REFUSAL OF PLANNING PERMISSION

APPLICATION NO. 2019/0261

Proposal Change of use from 4 bedroom/4 person HMO to 6 bedroom/11 person HMO and associated alterations

At 248 Sheffield Road, Barnsley, S70 4PP

Proposed First Floor Plan 1:50

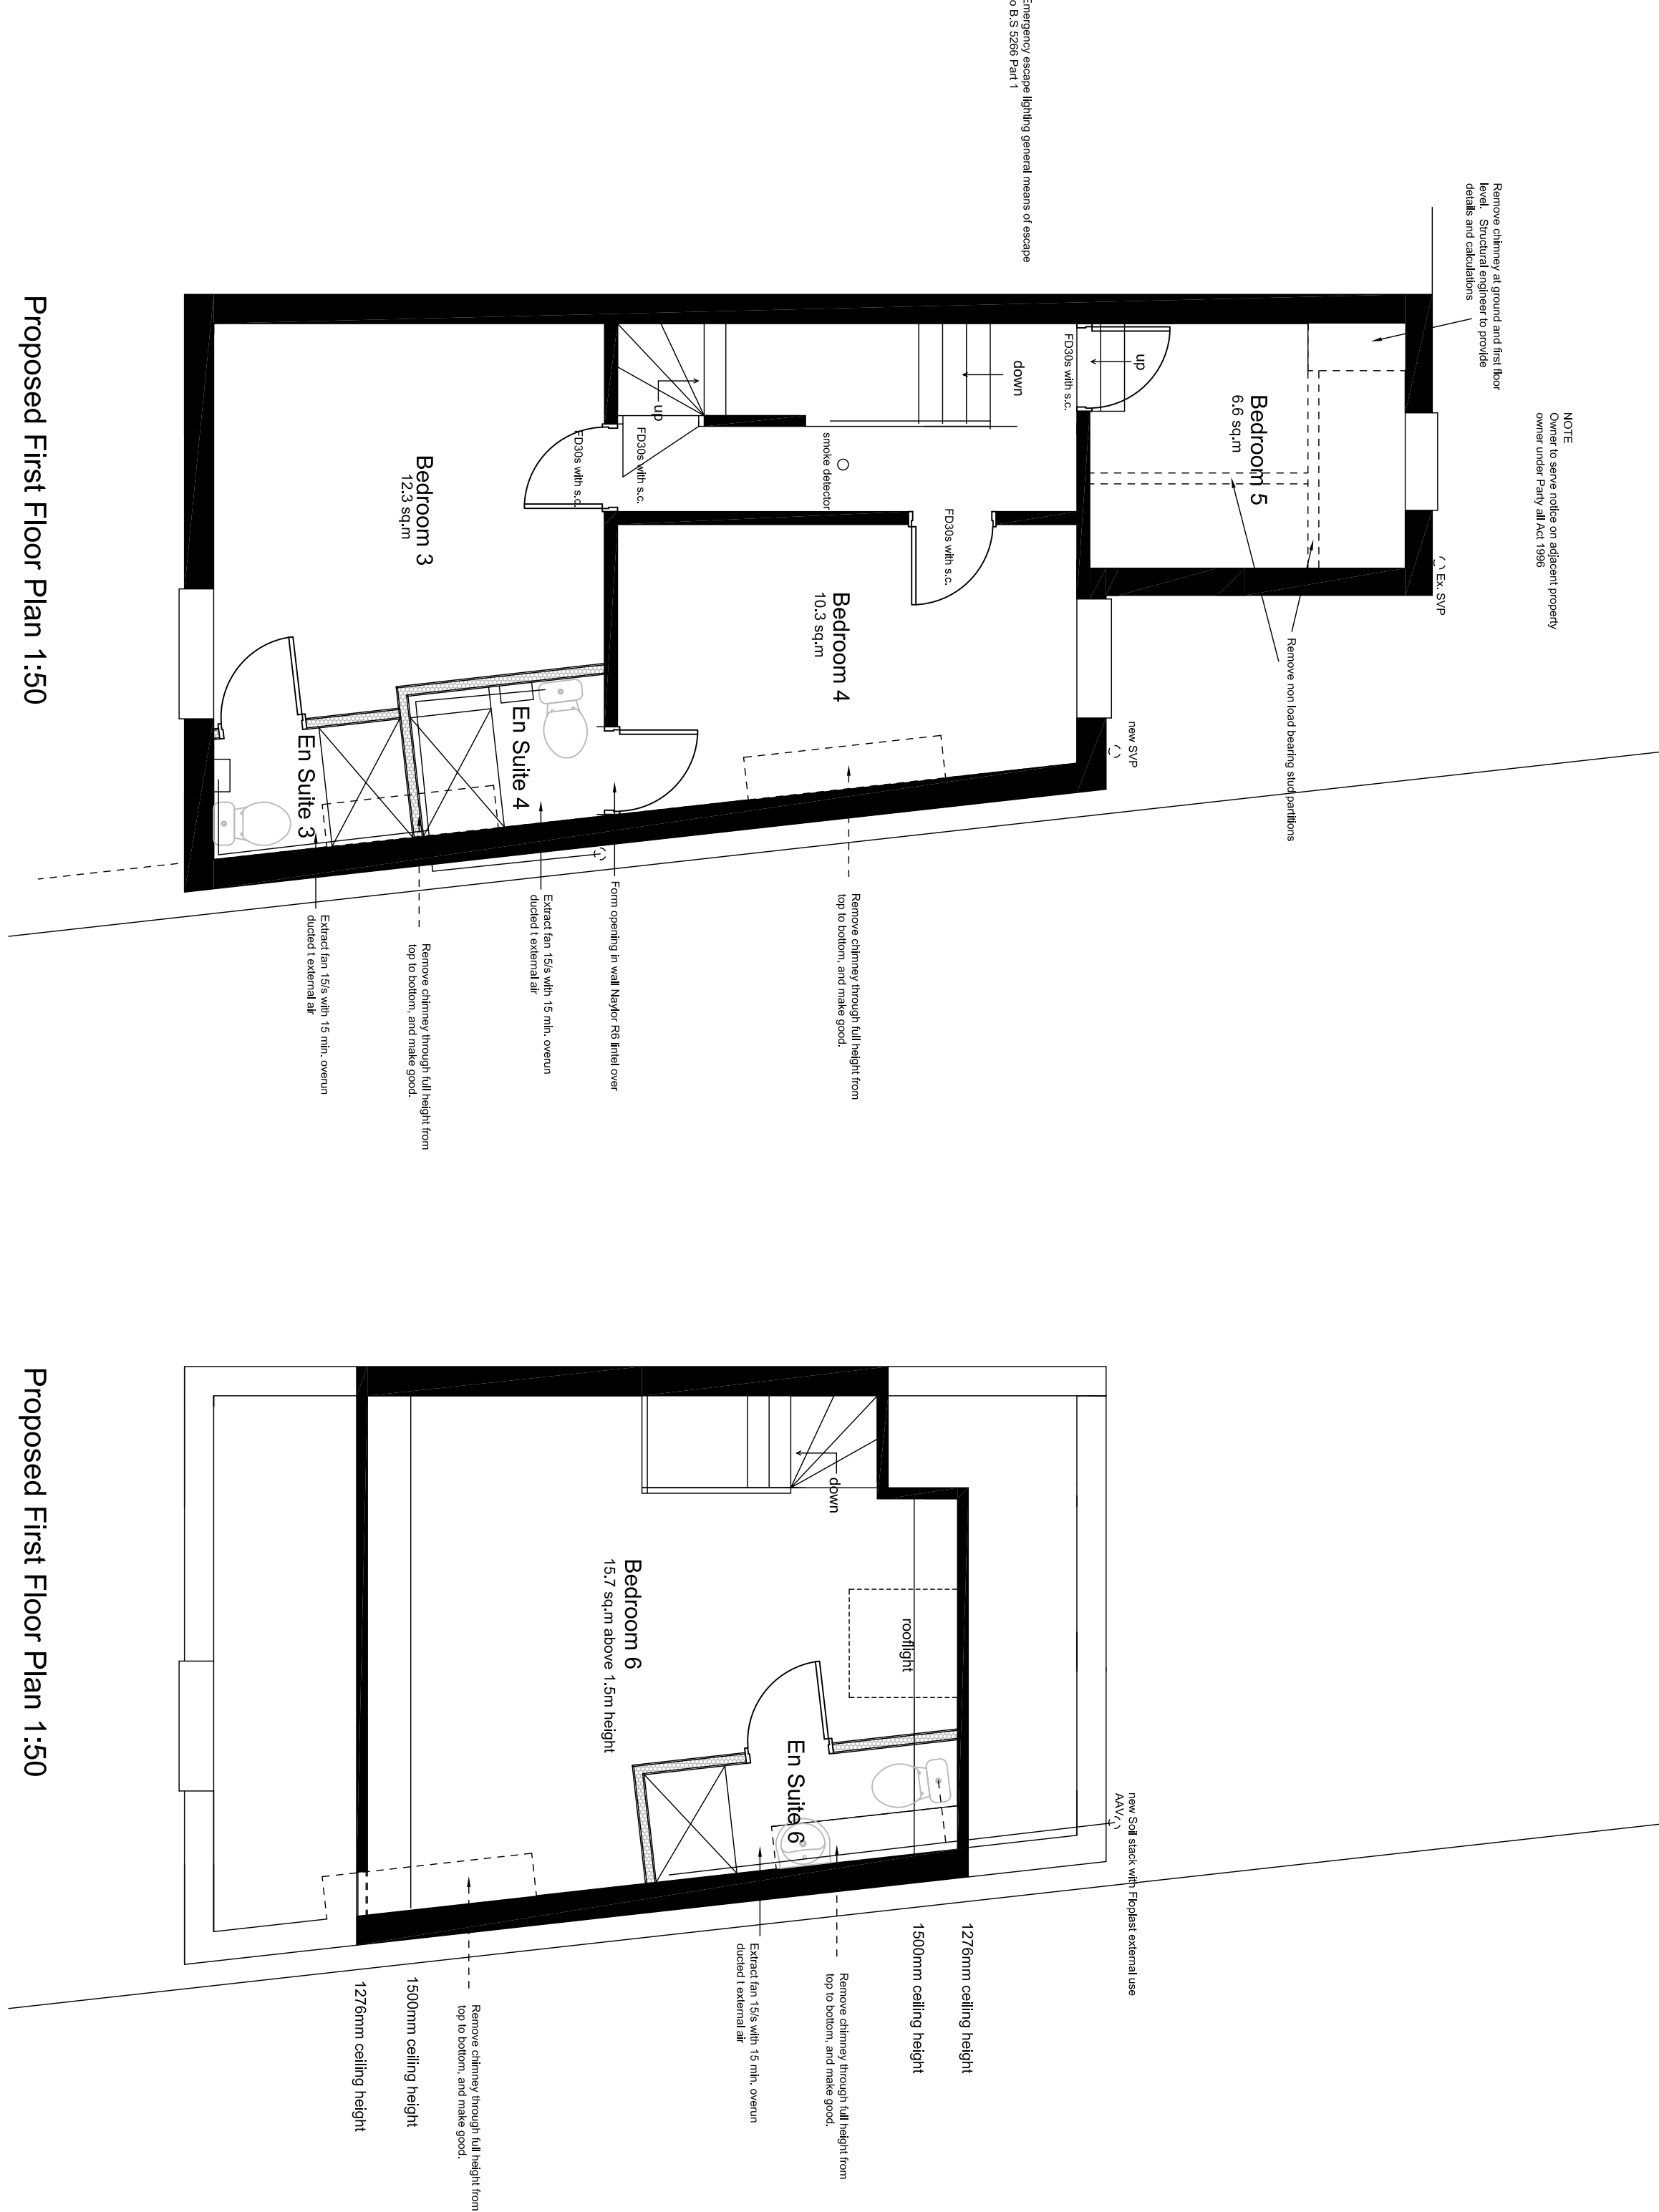
- 1 In the opinion of the Local Planning Authority the provision of 6 bedrooms within this HMO is excessive. 3no. of the 6 bedrooms would fall short of the internal spacing requirements set out in the South Yorkshire Residential Design Guide and the shared facilities would fall substantially short of the requirement. As such, the proposal would be contrary to the Council's 'Design of Housing Development' and Local Plan Policy GD1 'General Development' as it would have an adverse effect on the living conditions of existing and future residents.
